From: Roger Spencer
Sent: 21 June 2019 11:59
To: Planning.Responses
Subject: RE: Planning Consultation on: M/52/19/PL & M/51/19/CLE

APPLICATION NO: M/52/19/PL

Site Address: Gendarshe (now Sea Song) Manor Way Elmer PO22 6LA

Description of Works: Erection of 900mm high brown picket fence to rear

~~SEASONG~~
Gendarshe, Manor Way, Elmer, Bognor Regis, PO22 6LA

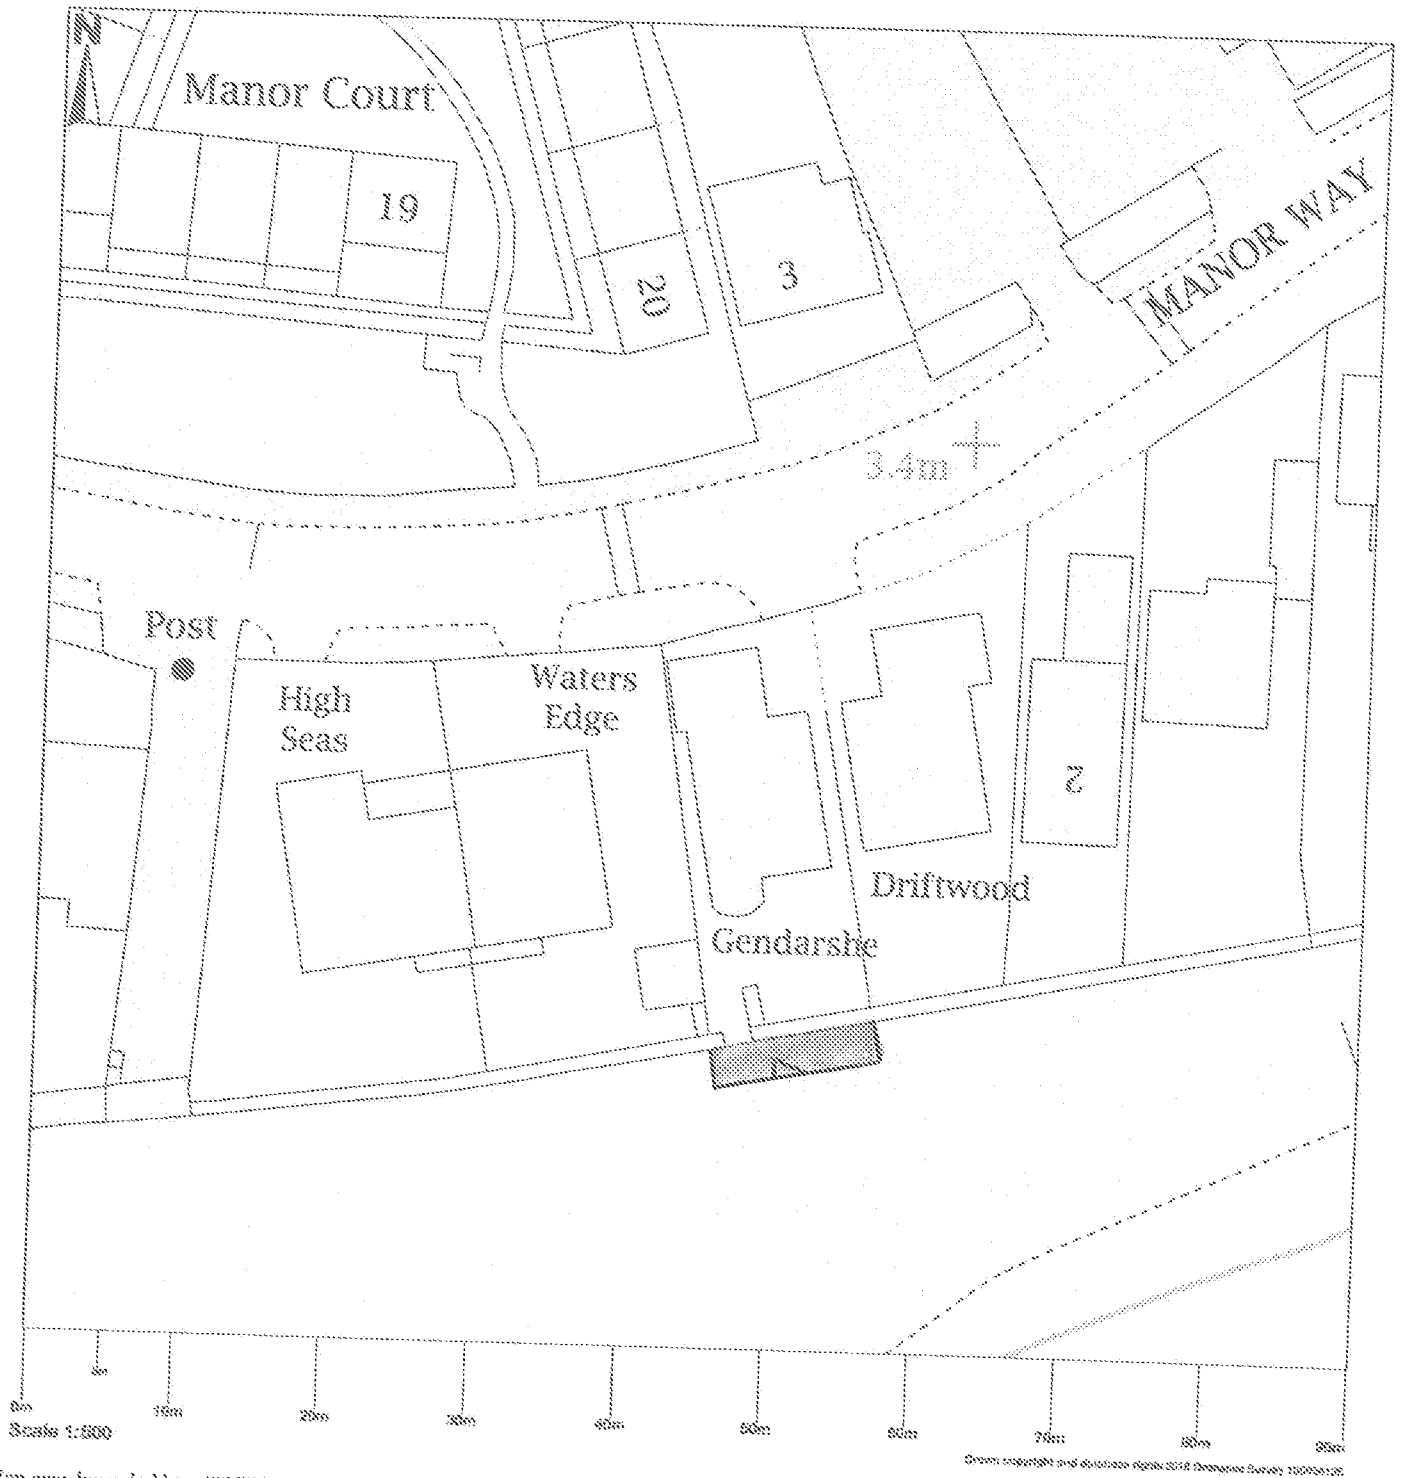
WRT land ownership; I think the applicant may have a different view to that agreed between myself and the Crown Estate (Arun is a lease holder of the Crown's Foreshore). Whilst it would be normal for the boundary (HWM) to be established on a day to day basis (with the tide and current induced movement of sand/shingle), the sudden intervention of the scheme of the early 1990s fixed the effective HWM boundary. We have established where HWM effectively was on the day the scheme started – this is shown in green above. This green line is seaward of the 'red line' of the application and so there is not an issue in this respect.
